**WEST SUSSEX COUNTY COUNCIL
STRATEGIC PLANNING CONSULTATION**

SUBJECT: EG/98/14/PL - Construction of 3 no two storey detached houses with new access.

Rear Of 59, Elm Grove, Barnham, West Sussex, PO22 0HJ

Drawing Title
Proposed Site Layout

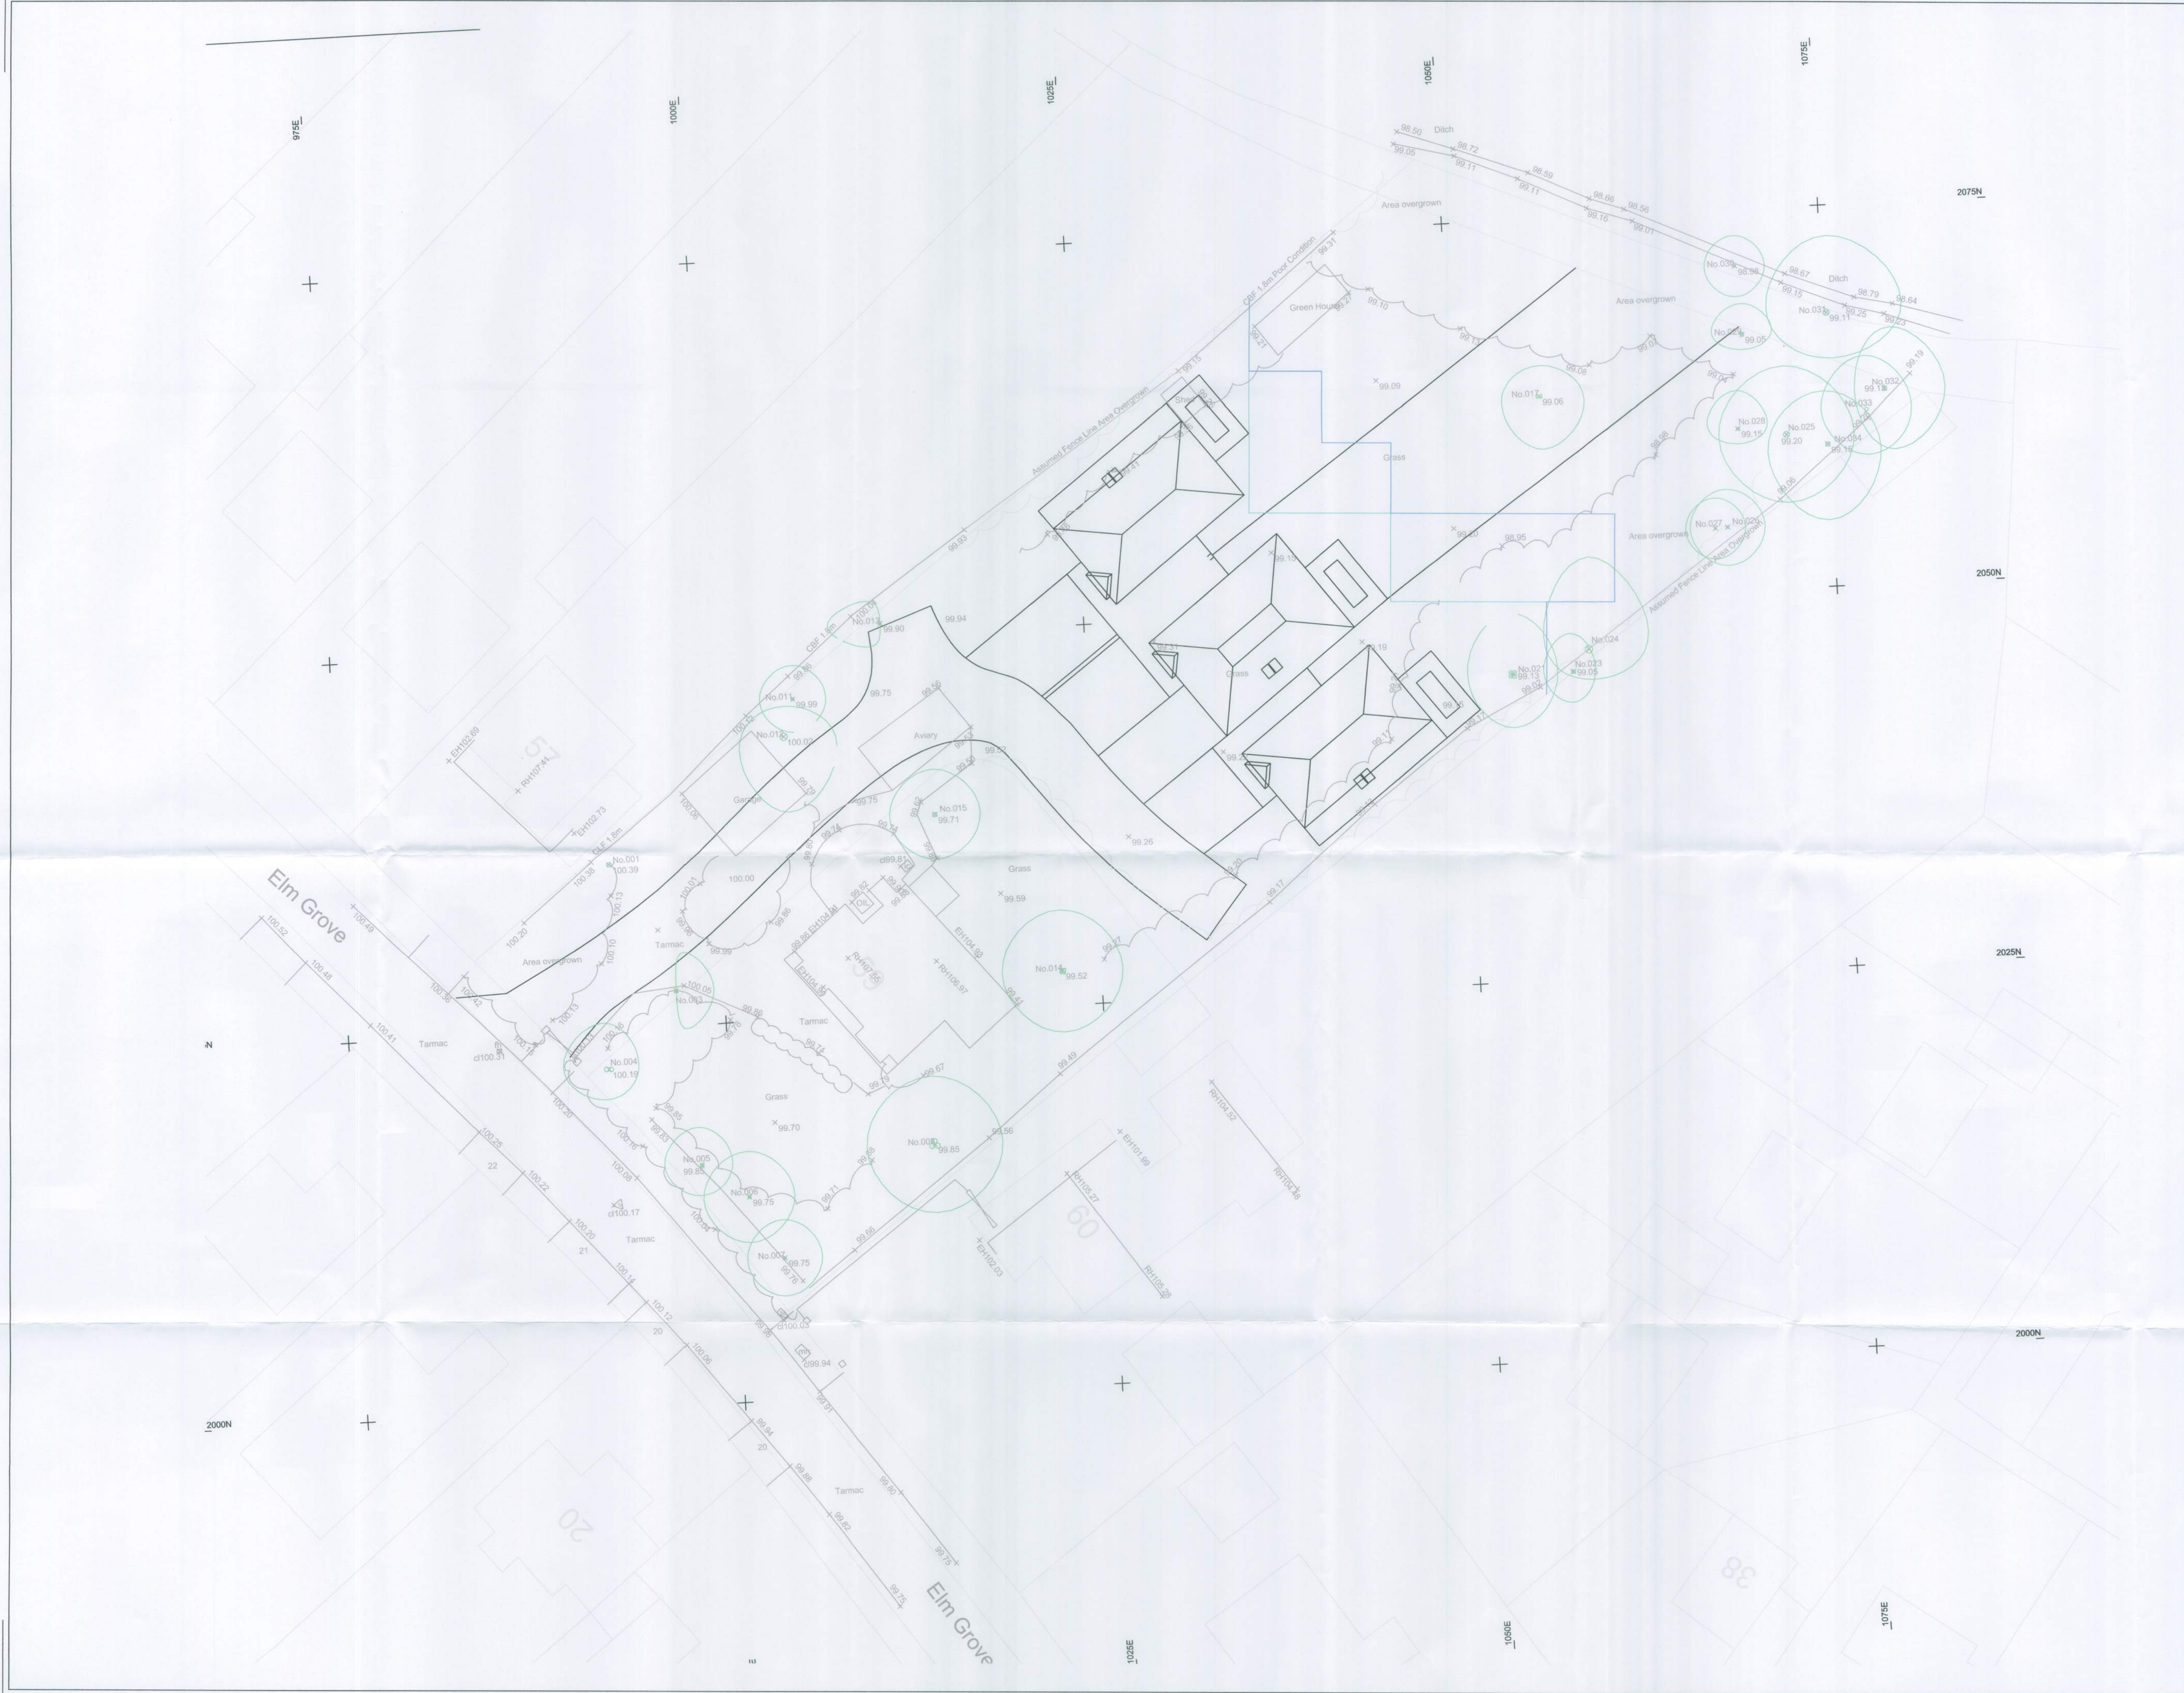
From an inspection of the plans the proposed access road appears to be approximately 4.5m in width, with adequate space for vehicles to turn on site and exit onto Elm Grove in forward gear. In terms of parking the proposed spaces meet with the requirements of the WSCC Parking Demand Calculator (PDC).

The LHA would advise that the access drive be constructed of a bound material, if it is to be constructed from shingle, this may result in material being dispersed onto Elm Grove affecting the surface of the road. The applicant should provide a gravel trap or area of block paving, or other bound material, at the point of access onto Elm Grove on land within the applicant's control.
